## COMMENTS:

Operation Permit

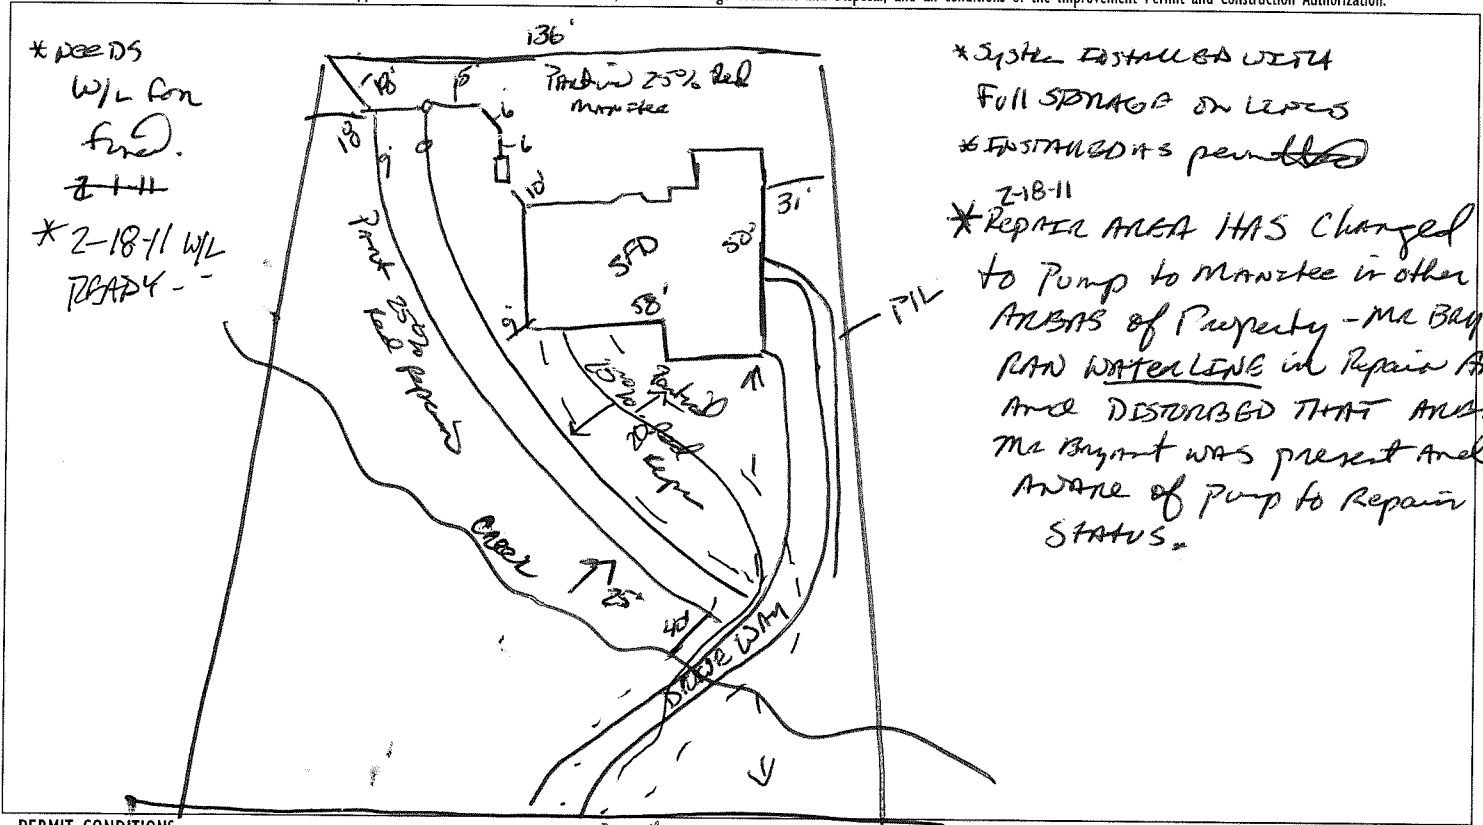
ON FEB 15<sup>TH</sup> System WAS INSTALLED BY APLOCK LOCATIONS - NEEDED  
WATER LINE TO BE INSTALLED AS WELL AS power (pump) - I DISCUSSED  
MEASURES TO KEEP REPAIR AREA INTACT AND HOW TO RUN W/L  
IN 2 DIFFERENT AREAS TO ENSURE PROPER PLACEMENT DUE TO SPACE  
MR BRYANT AGREED TO RUN THE WATERLINE IN EITHER OF THE TWO  
WAYS WE DISCUSSED TO AVOID 10' ENCROACHMENT ON DRIVEWAYS AND  
REPAIR AREA. ON 2-18-11 - NOTES - VOICEMAIL AND FILE WERE  
ON MY DESK PERTAINING TO MR BRYANT AND HIS FIRM. HE ALSO  
CAME IN THE OFFICE; ASKED TO SPEAK TO ME + TOLD ME  
THAT WATER LINE WAS IN AND READY FOR FINAL. I  
TOLD HIM THAT I WOULD COME STRAIGHT OUT TO INSPECT.

9:30 I WENT OUT TO TAKE A LOOK FOR FINAL AND MR BRYANT RAN  
THE WATER LINE IN A MANNER THAT WAS NOT DISCUSSED  
AS ALLOWABLE. THE INSTALL SEEMED TO BE 10' OFF OF DRIVEWAYS  
AND I EXPLAINED WHAT HIS MISTAKE HAD DONE  
AND IT WOULD CHANGE REPAIR AREA AND REQUIRE  
A PUMP TO REPAIR THE SEPTIC BECAUSE OF  
THE PLACEMENT OF THE W/L HE INSTALLED.  
CLIENT WAS INFORMED. W/L AND DITCH  
DISTURBED REPAIR AREA.
